**Brighton & Hove
City Council**

Date: 7 November 2022
Our Ref: BH2022/03179
Your Ref:
Officer Phone: 291075
Officer E-mail: rebecca.s.smith@brighton-hove.gov.uk

Application No:	BH2022/03179
Site/Property:	Highcroft Lodge Highcroft Villas Brighton BN1 5PZ
Description:	Reference: 1999/519/EC Installation of 12no. antennas installed on pole mounted support structures in 3 separate locations across the rooftop of Highcroft Lodge to a maximum height of 24m.

TITLE
 SITE PLAN
 PROPOSED

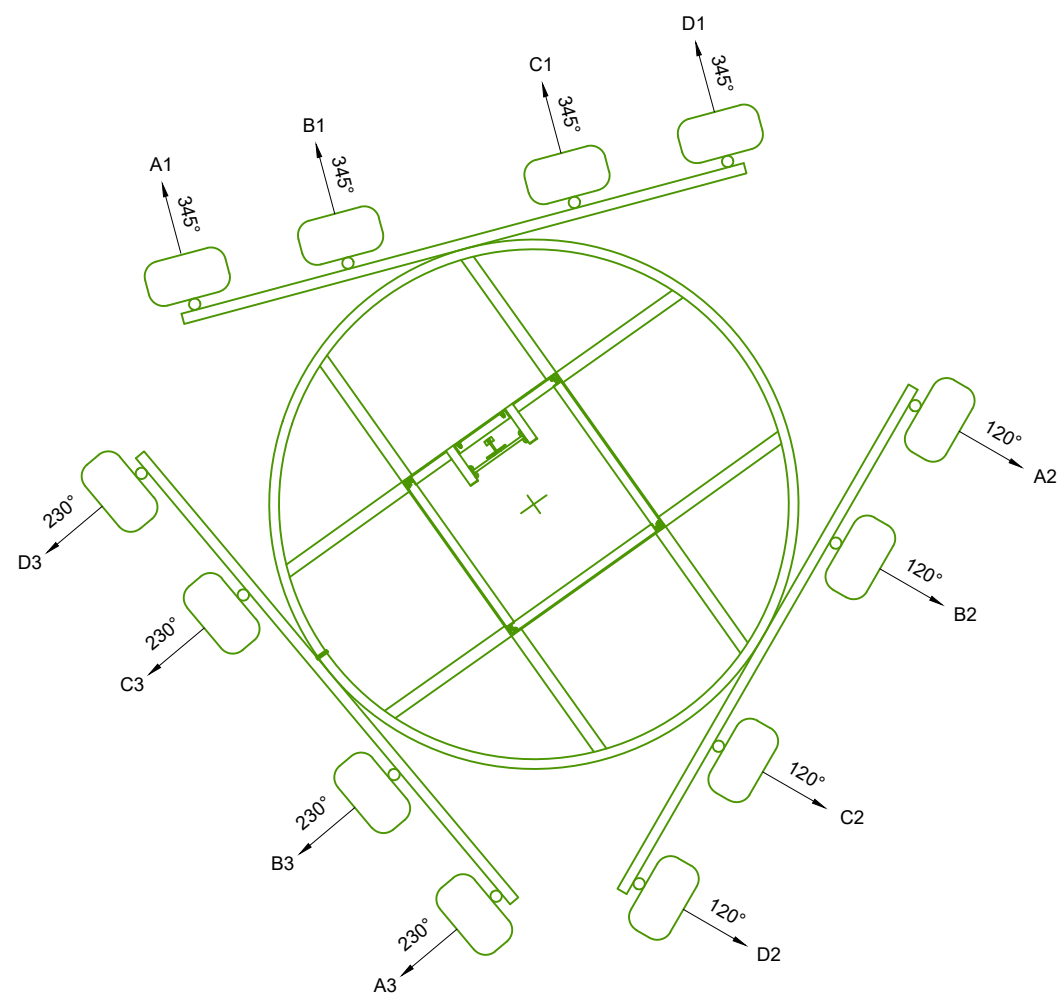
1. The proposed development by virtue of the bulk and massing of the radio equipment and extent of the railings proposed would not represent permitted development as it would not be minimised in its effect on the appearance of the building as per the requirements of Schedule 2, Part 16, Class A.2(1) (a) of the Town and Country Planning (General Permitted Development) (England) Order 2015 (as amended).

2. The proposed development by virtue of the bulk and massing of the radio equipment and extent of the railings proposed would not represent permitted development as the impact upon the street scene would not be minimised as per the requirements of Schedule 2, Part 16, Class A.2(1) (b) of the Town and Country Planning (General Permitted Development) (England) Order 2015 (as amended). In particular the extent of the railings would be prominent in views up and down Highcroft Villas.
